Re: Matthews Ridge Amenity Center and Pool

This department has reviewed the plans you submitted for the Matthews Ridge swimming pool to be constructed at 369 Chestnut Oak Ln., Lillington, NC. This plan review was conducted in accordance with the current North Carolina Rules Governing Public Swimming Pools (15A NCAC 18A .2500).

G0.3

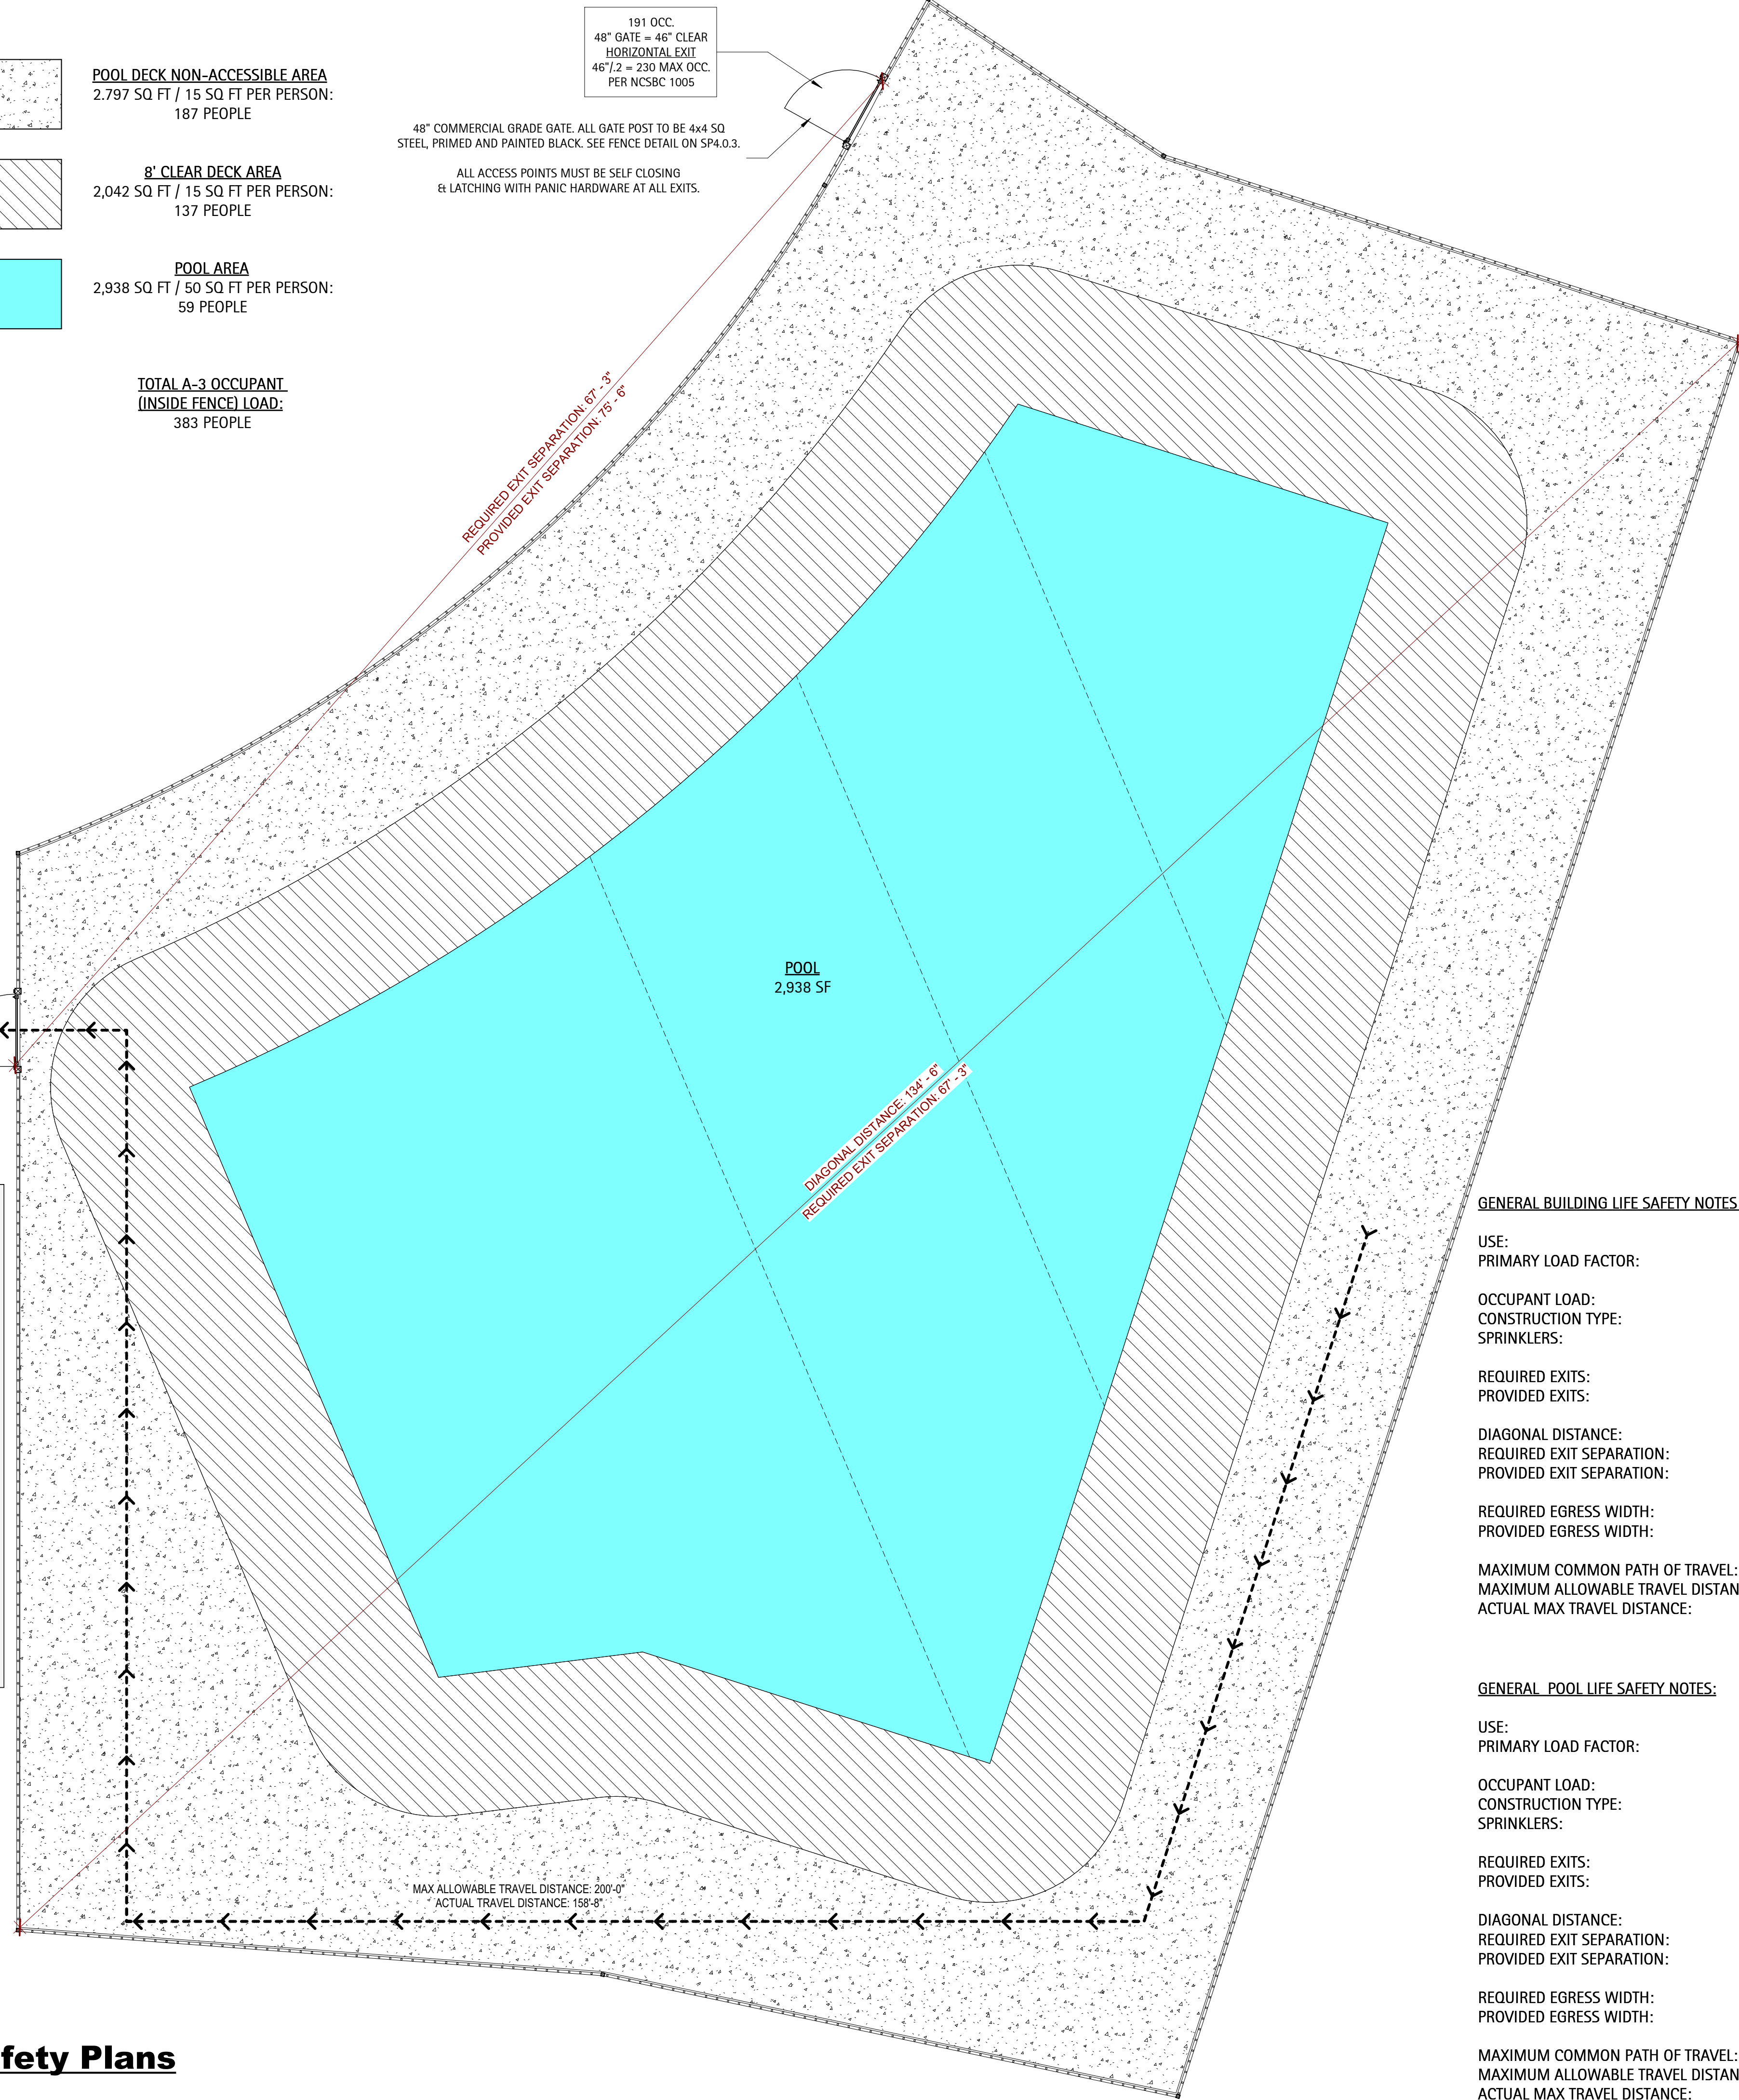
-No emergency phone is shown on exterior elevations of the building or on the Electrical Plan. A single listing of phone location is present on page G0.3 Life Safety Plan. This location is approved but should be consistently shown throughout plans to ensure proper placement and construction.

P2

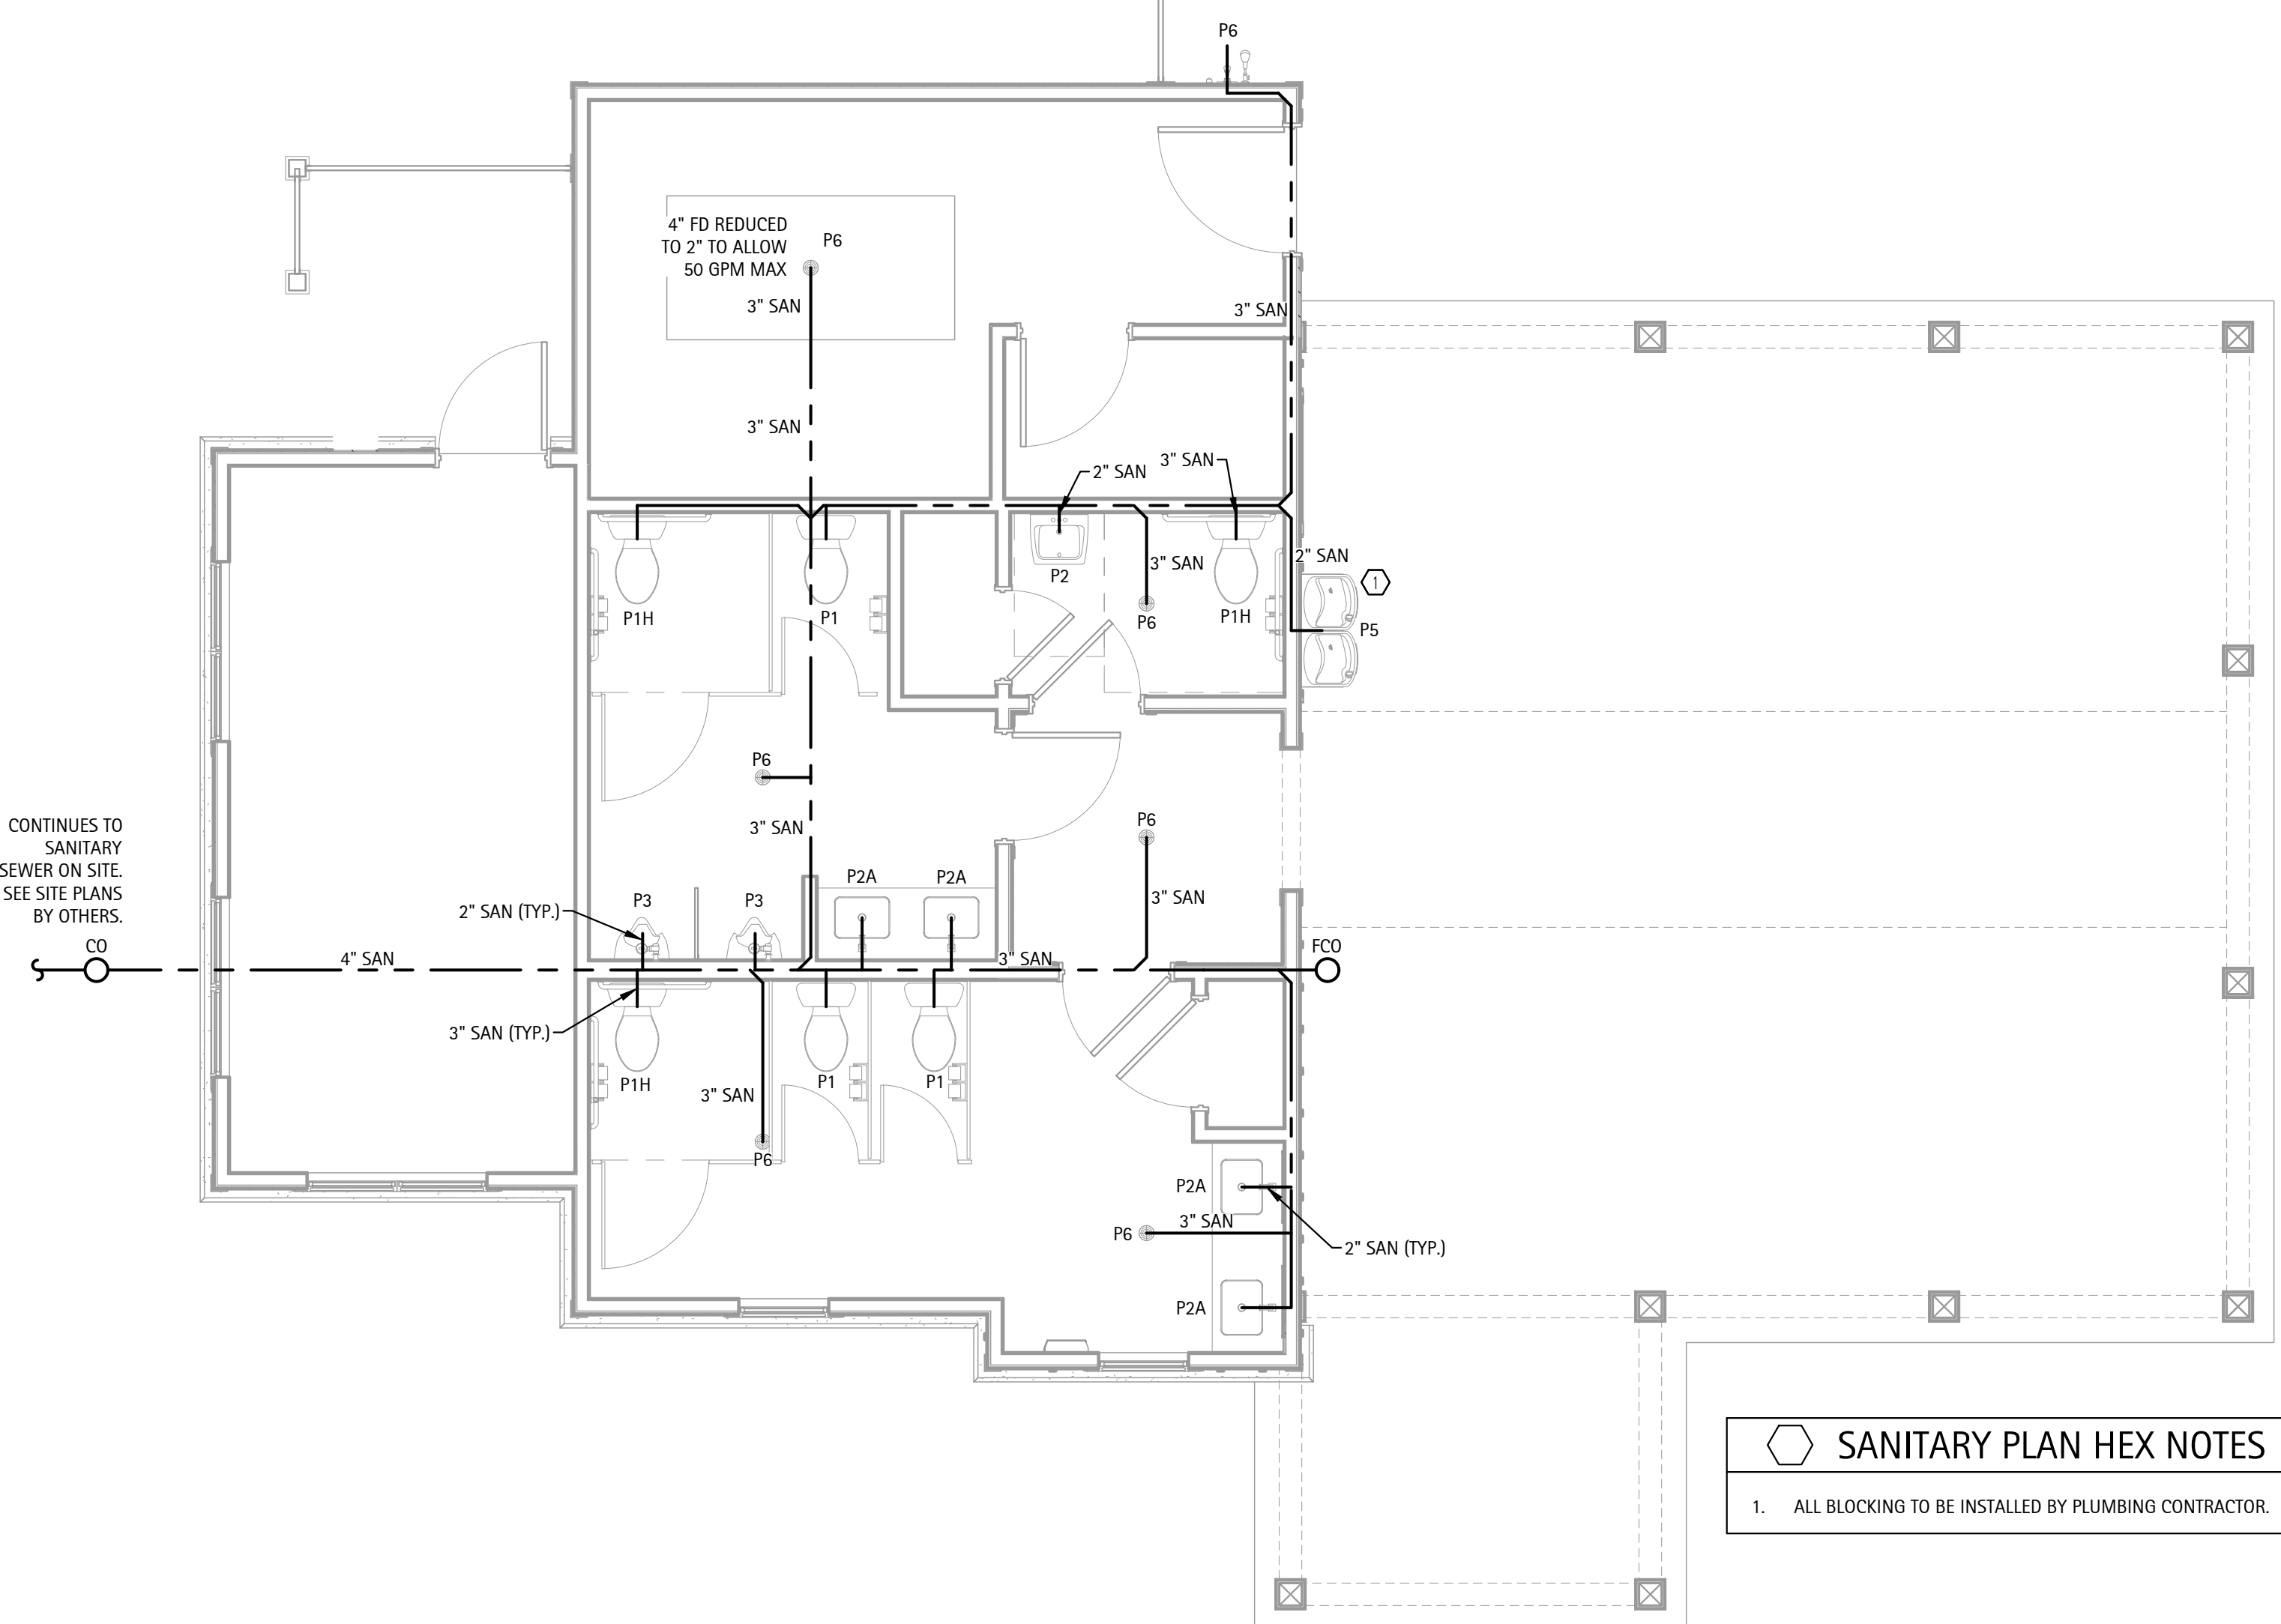
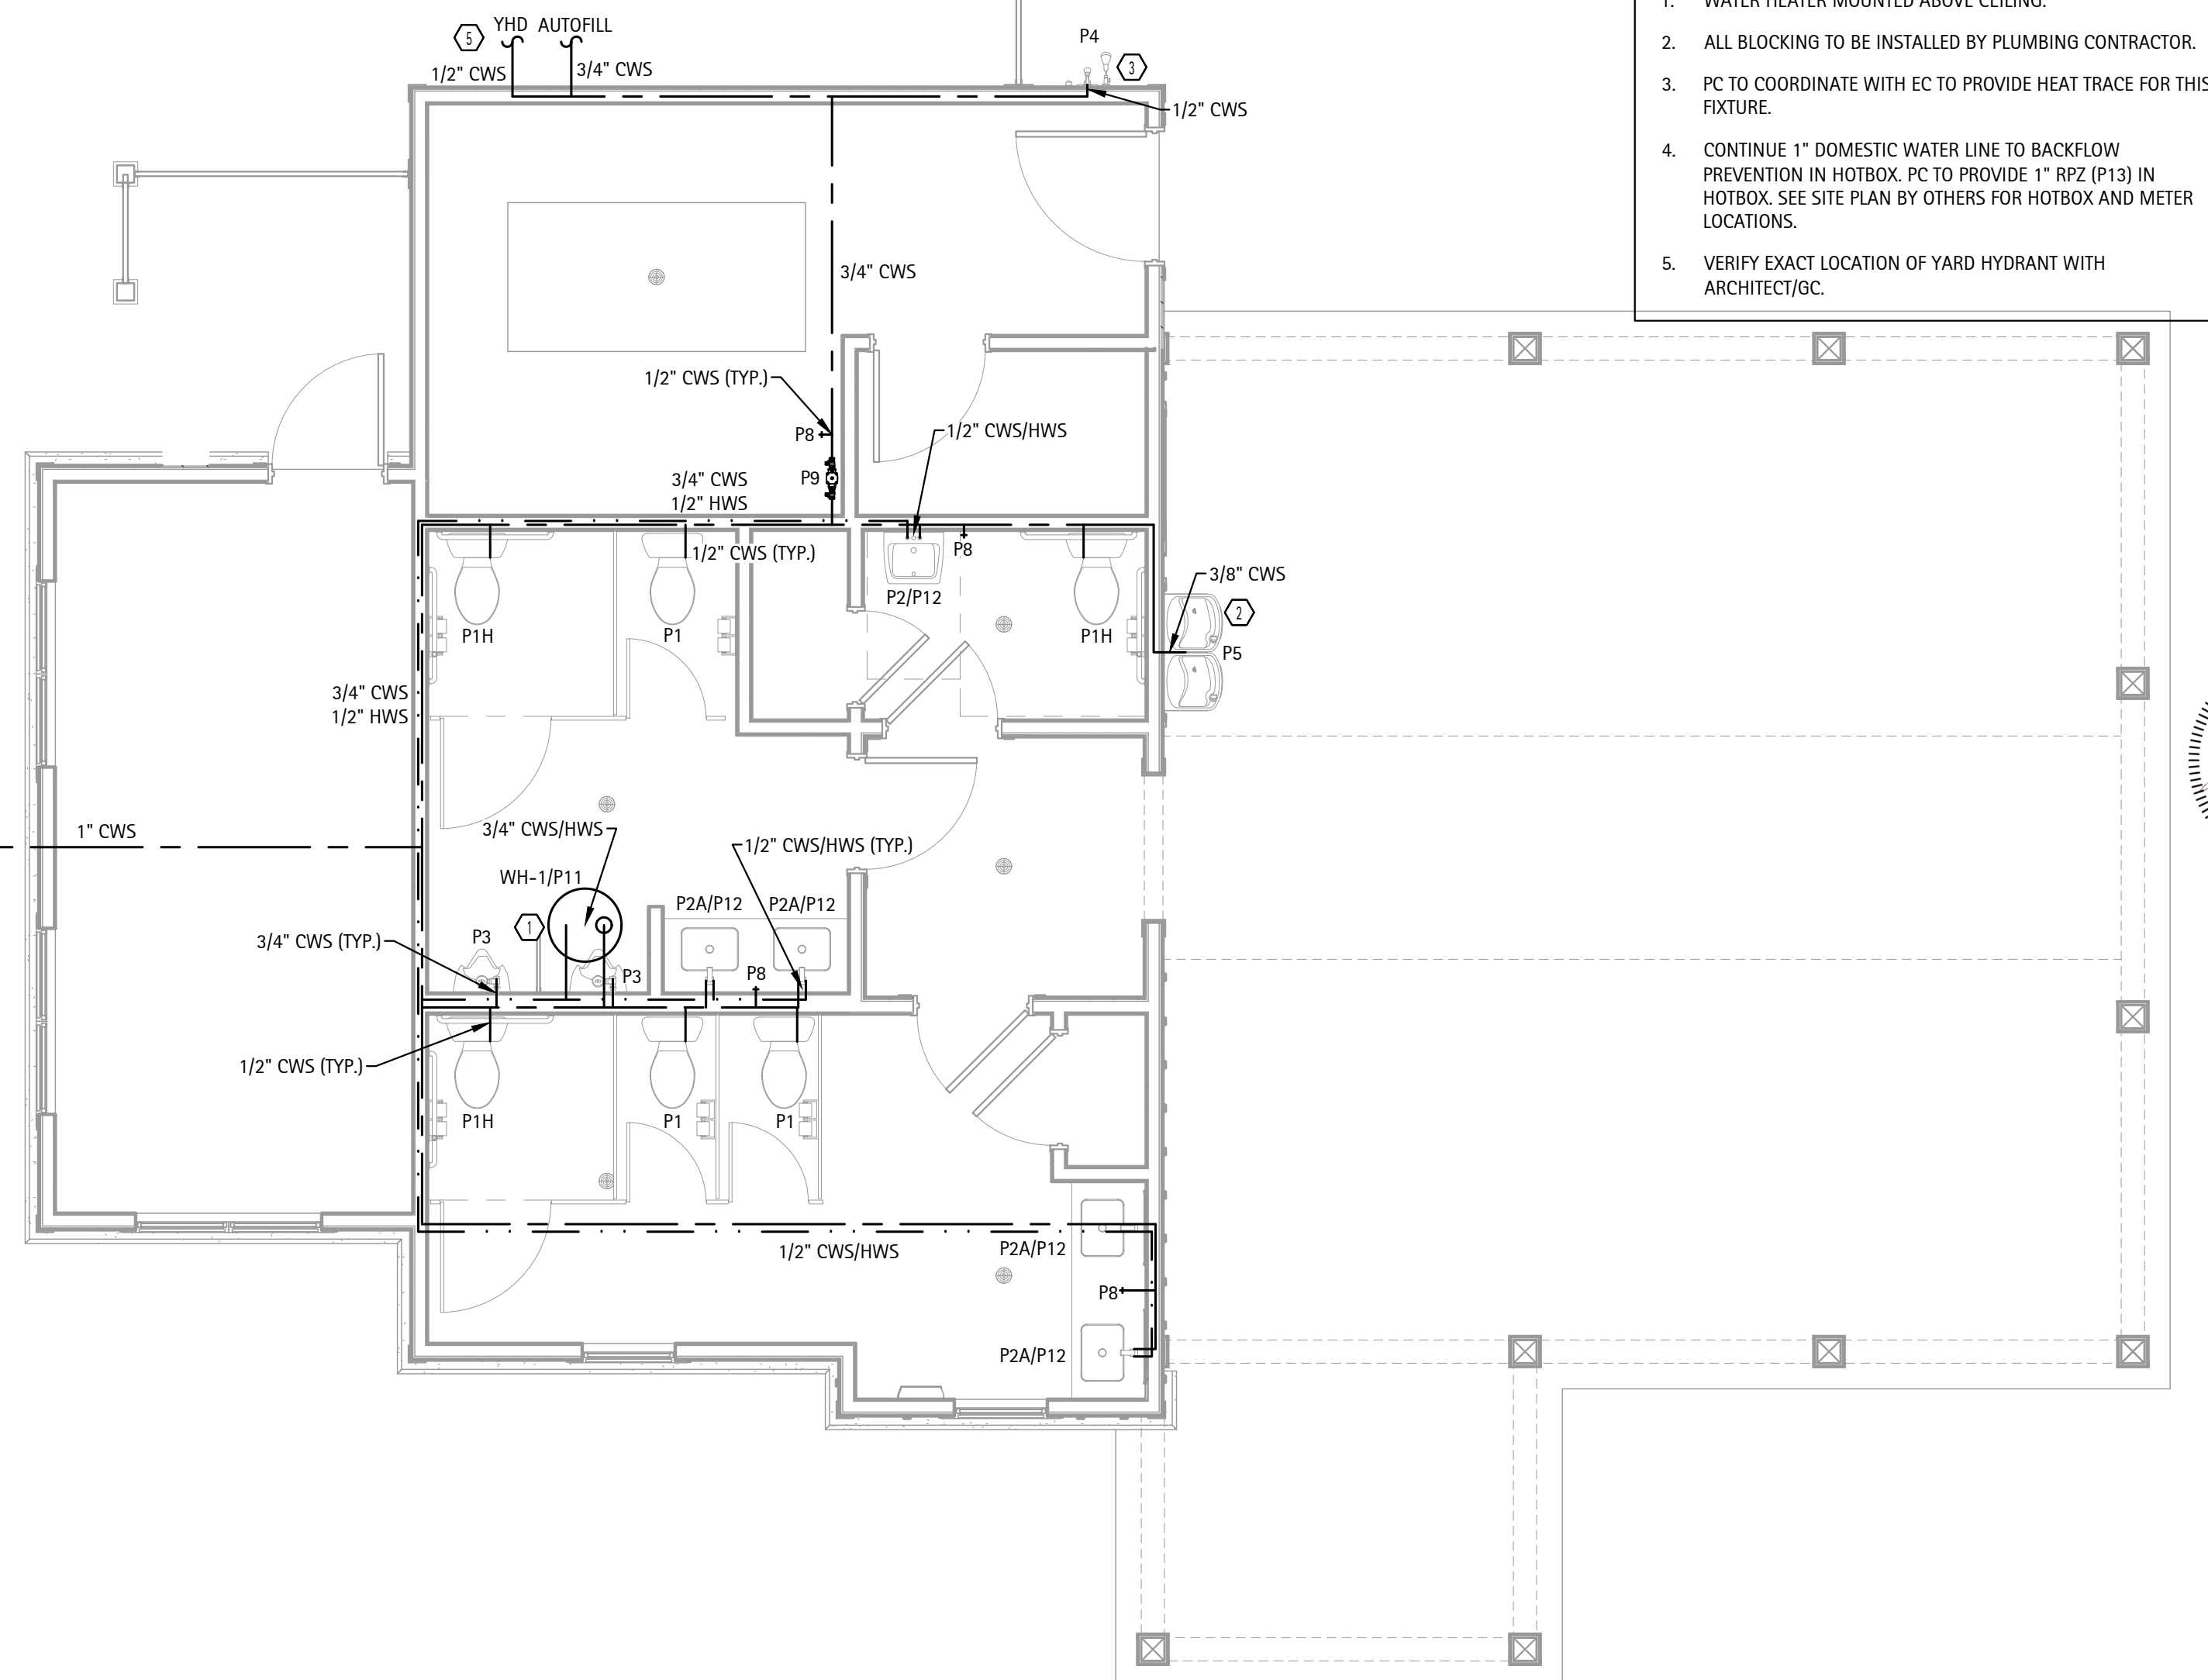
-The yard hydrant as shown on page SP3.0 shall be located so as to allow all areas of decking to be reached with a 100' hose if this is the only provided hose bib. The yard hydrant shall also be located so as to not obstruct decking or be a foot hold. A hose bib is indicated with the rinse shower on page SP2.0 but not on other pages. No frostproof hose bib is indicated on the plumbing plan pages P1 and P2.
